Planning & Urban Development Department

October 23, 2014

Project Name: Pamela Road Subdivision Amendments
Address: Pamela Road
Applicant: Telos Capital
Planner: Nell Donaldson

Project ID: 2013-097
CBLs: 389-D-10, 11, 12, 13, 14
389-E-2, 3, 4, 5, 6, 7

Drawing Name and Location:
AMENDED SUBDIVISION PLAN
 CRESTVIEW ACRES, PORTLAND, MAINE

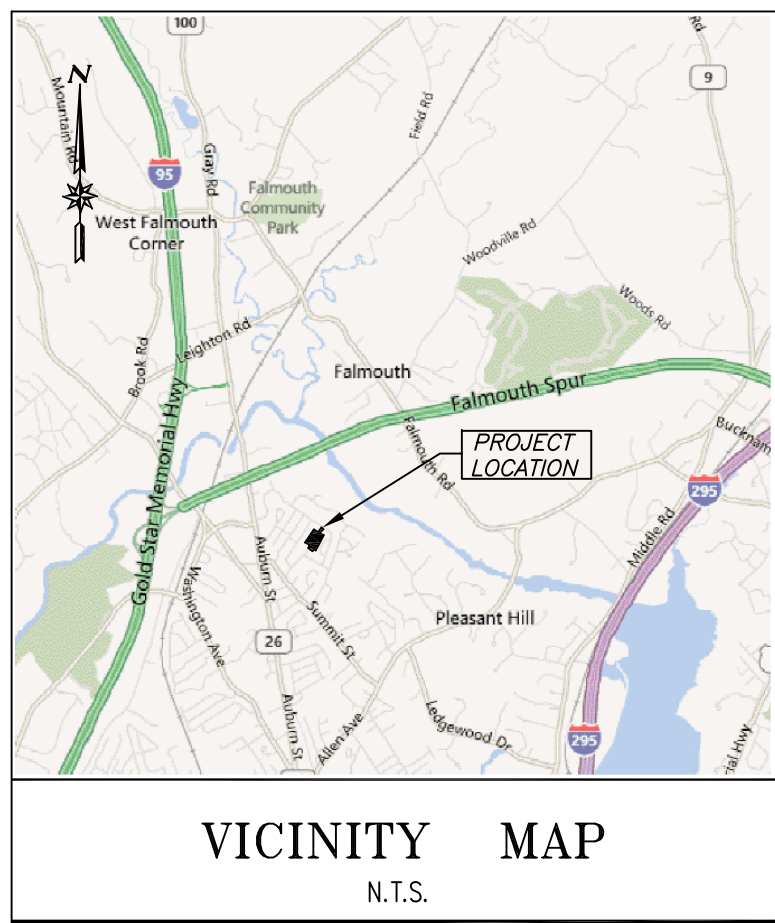
1. The applicant shall submit a revised plat to address the comments of Bill Clark, of the city's Department of Public Services, including:
 1. Revising the extent to include the easting coordinate for southerly corner of Lot 33, and
 2. Showing coordinates for existing survey monument found on Alice Street in front of Lot 27. This helps with our GIS parcel mapping and street ROWs plan; and
2. The applicant shall add a note to the plat regarding future NRPA permitting for wetland fill on individual lots, for review and approval by David Senus, consulting civil engineer.
